**From:** Contact Centre (CRM) <contact@ribblevalley.gov.uk>  
**Sent:** 20 October 2025 18:24  
**To:** Planning  
**Subject:** Planning Application Comments - 3/2025/0724 FS-Case-758616933

**Planning Application Reference No.:** 3/2025/0724

**Address of Development:** Hawthorne Bungalow  
Rimington Lane  
Rimington

Ben Pentreath		1-4 Lamp Office Court Lamb's Conduit Street London WC1N 3NF T +44 (0) 20 7430 2424 benpentreath.com
PROJECT:	HAWTHORN, RIMINGTON	
TITLE:	PROPOSED ELEVATIONS 1:100 @ A1	
DRAWING NO:	HWTN-A-200	REV. NO: P
SCALE:	1:100 @ A1 1:200 @ A3	DRAWN BY: SC
DATE:	05/09/2025	CHECKED BY: RC

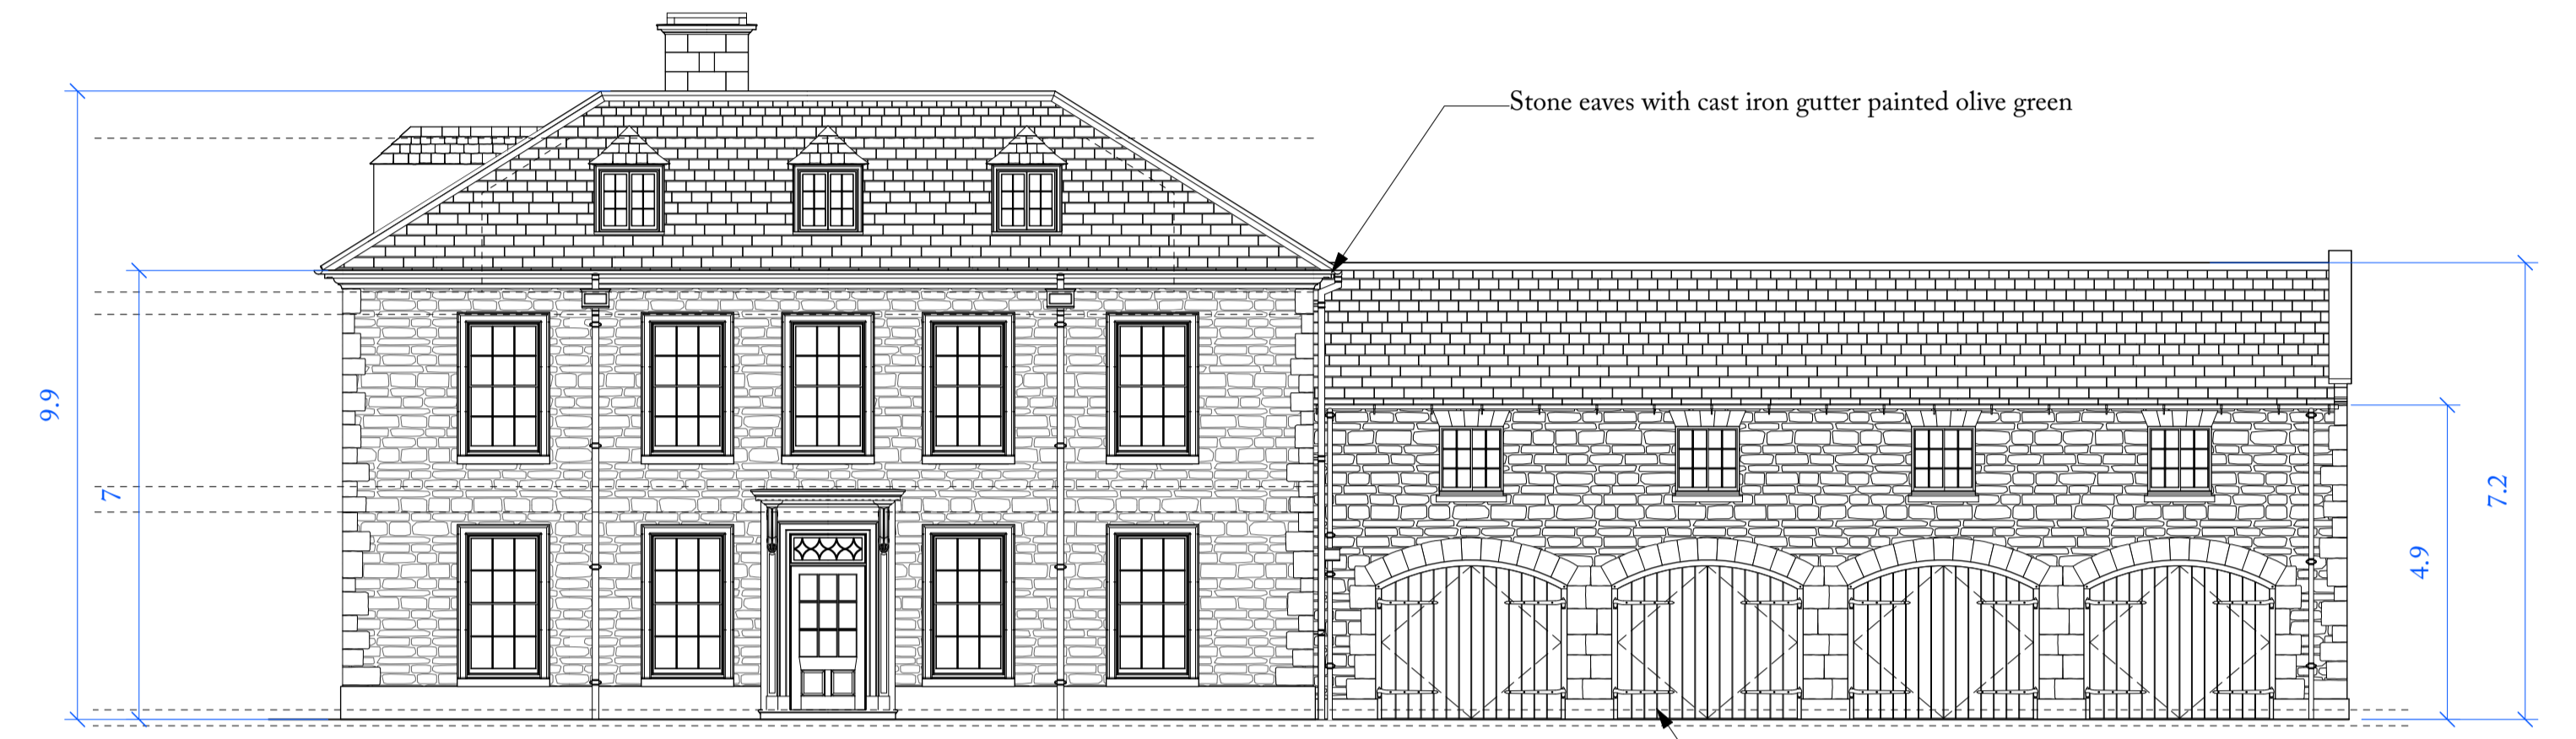
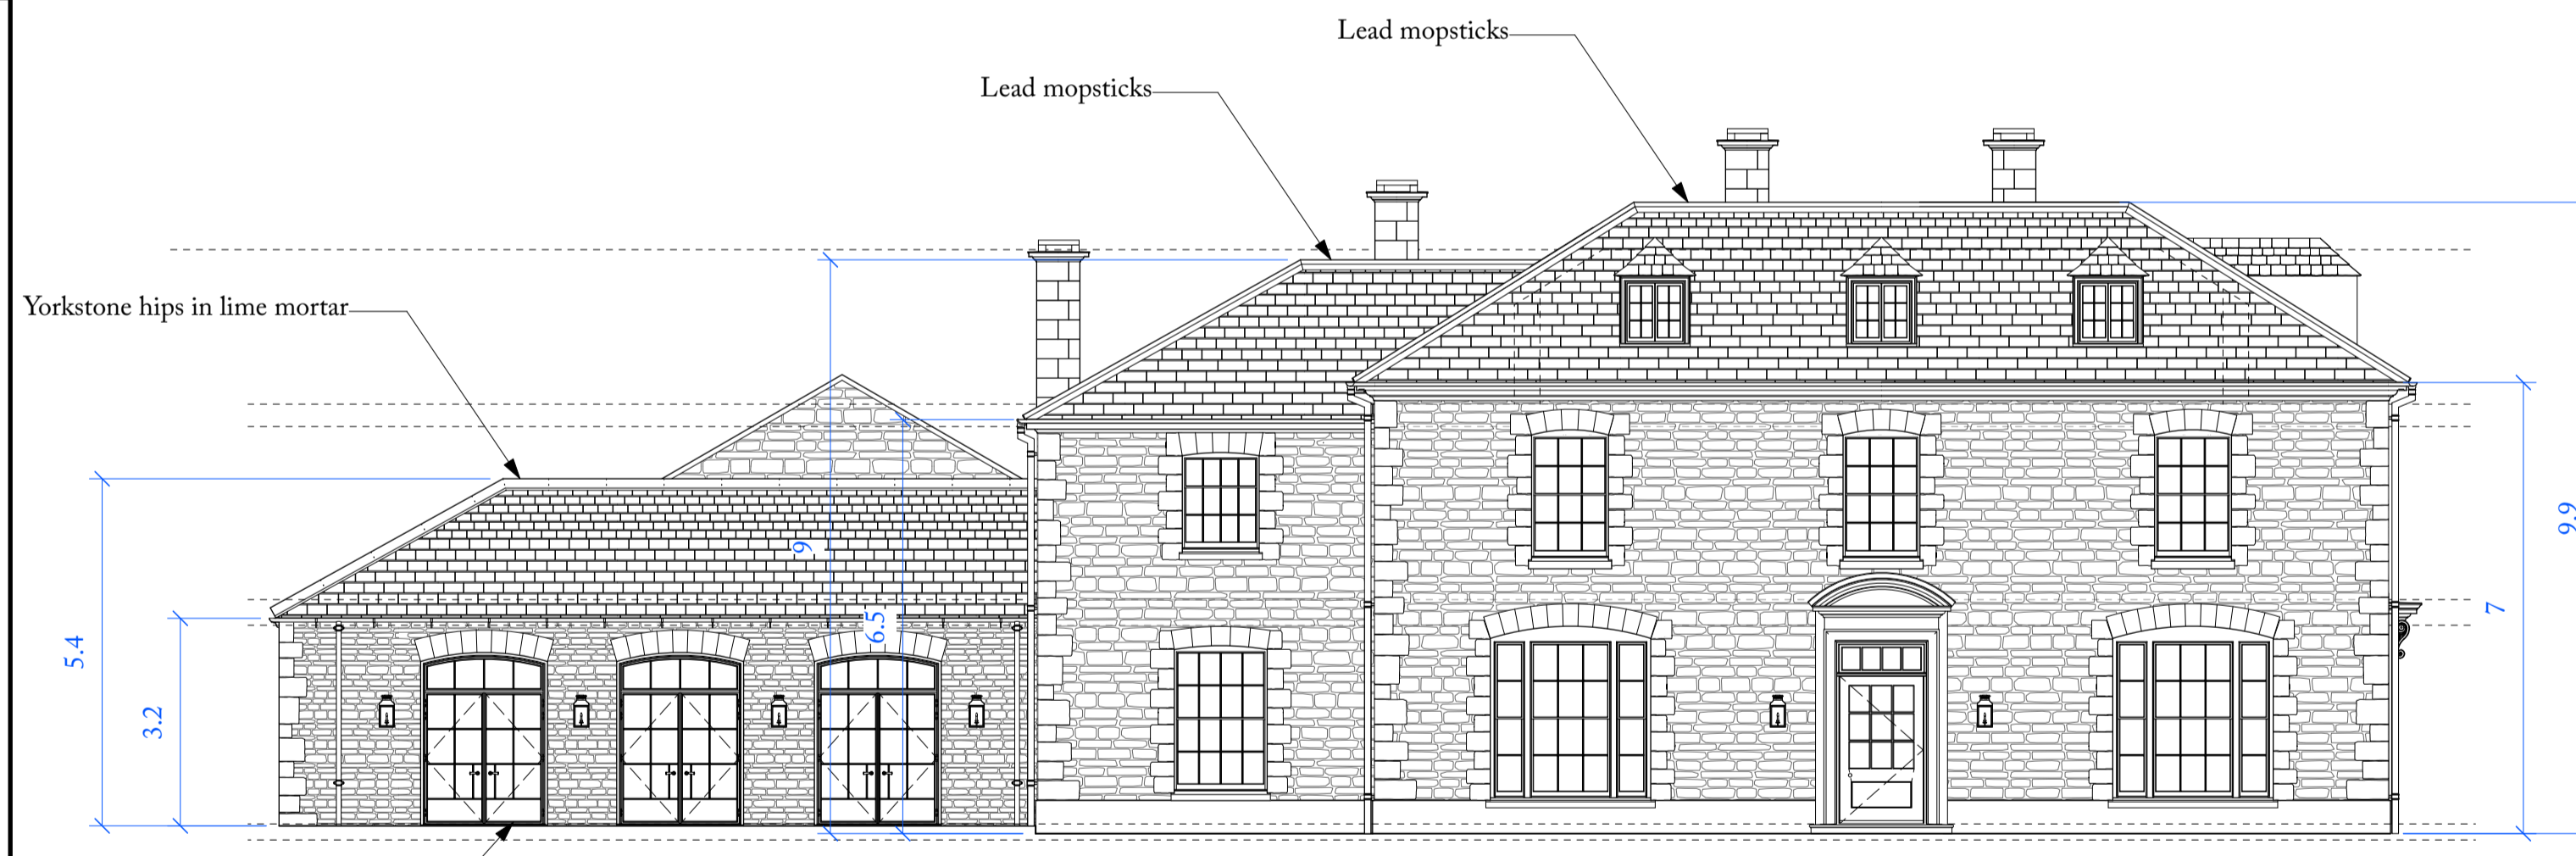
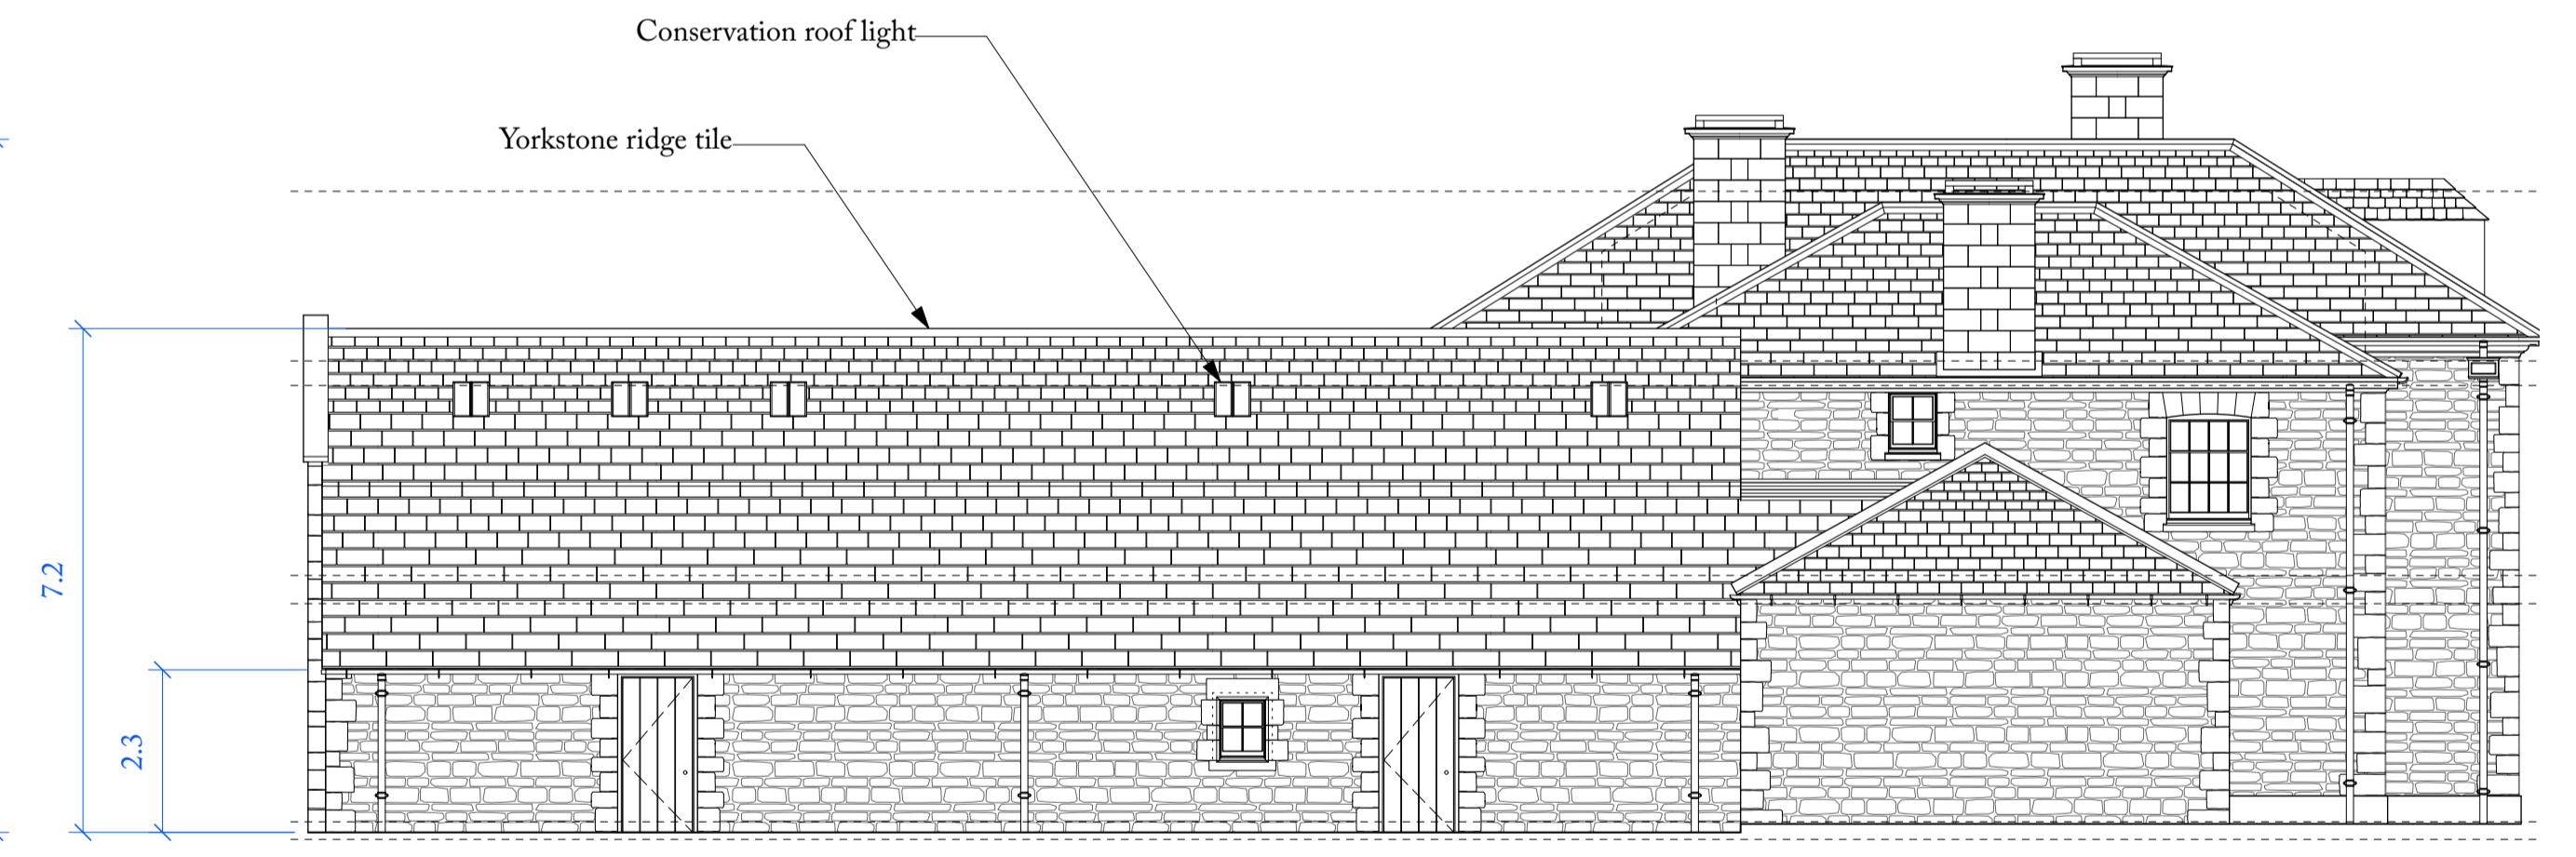
The position of the proposed development means it is the first property visible when entering the village from Chatburn and the protruding long expanse of wall is unsightly and it is an incongruous entrance feature compromising the visible amenity of the approach to the village. The proposed property is also out-of-character compared to other neighbouring properties, including a listed farmhouse and 2 barn conversions. Further, it will dominate the surrounding countryside and be clearly visible from Pendle Hill.

Ben Pentreath		1-4 Lamp Office Court Lamb's Conduit Street London WC1N 3NF T +44 (0) 20 7430 2424 benpentreath.com
PROJECT:	HAWTHORN, RIMINGTON	
TITLE:	PROPOSED FLOOR PLANS FOR PLANNING	
DRAWING NO:	HWTN-A-104.1	REV. NO: P
SCALE:	1:100 @ A1 1:200 @ A3	DRAWN BY: SC
DATE:	05/09/2025	CHECKED BY: RC

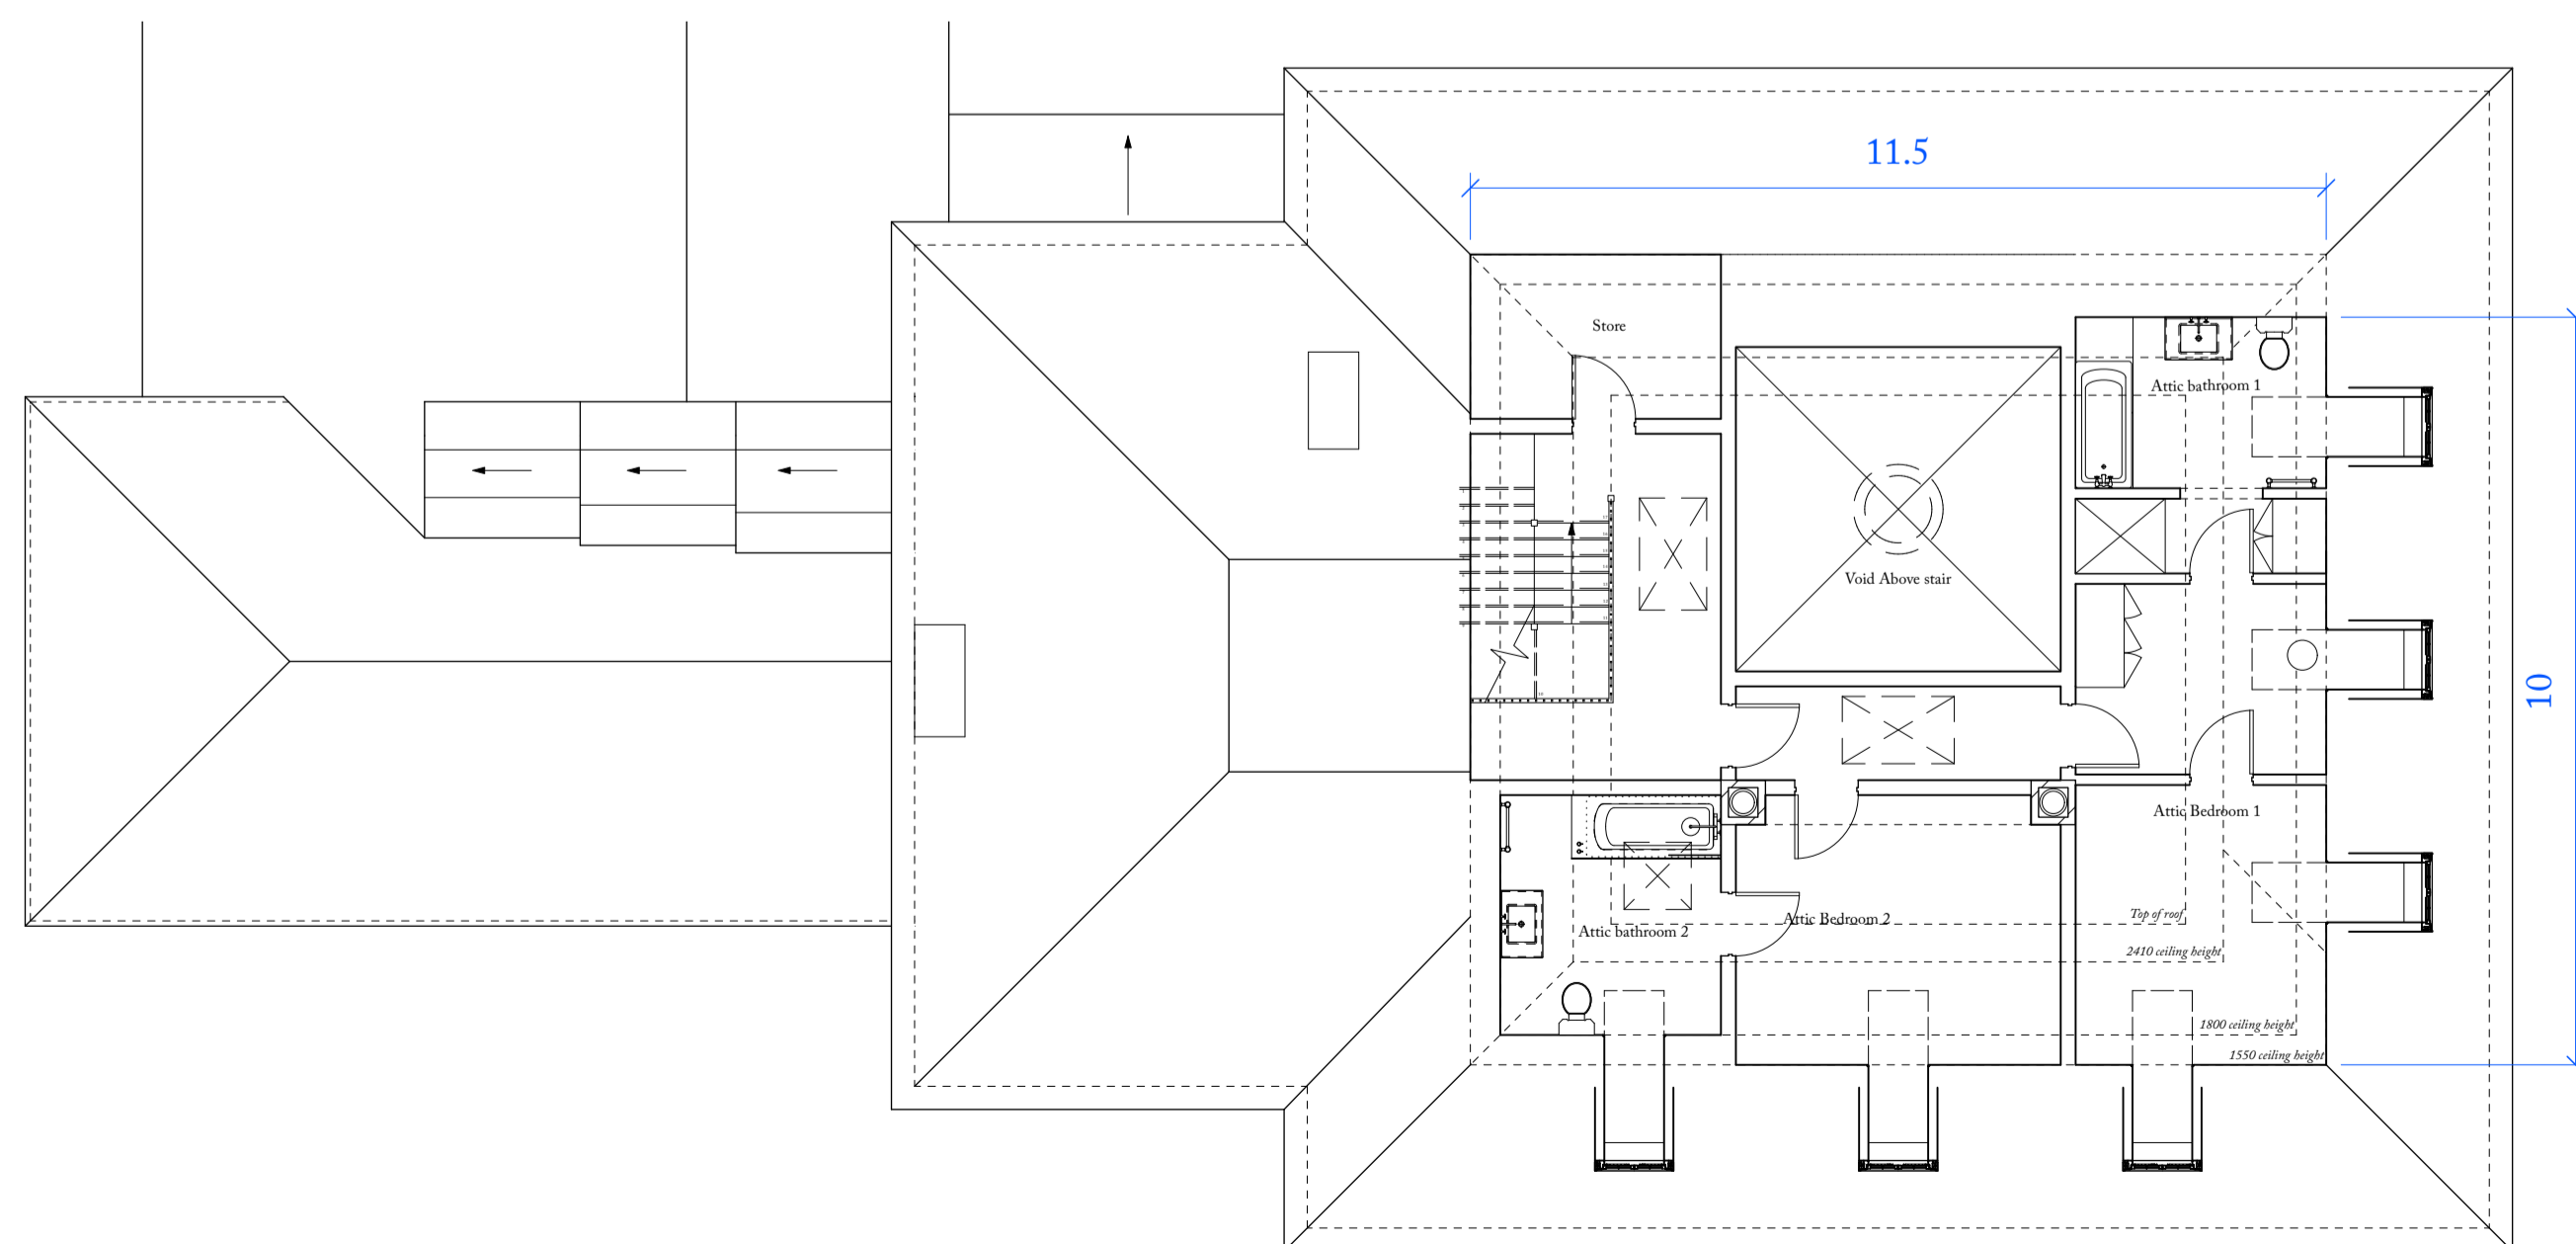
**Comments:** I understand the original planning permission was for a development of two storeys and of a size of 500m squared. This application is for a 600m squared property with three storeys and 7 bedrooms, so is therefore of a considerably increased size which I consider to be over-development and question why is there a need for 7 bedrooms.
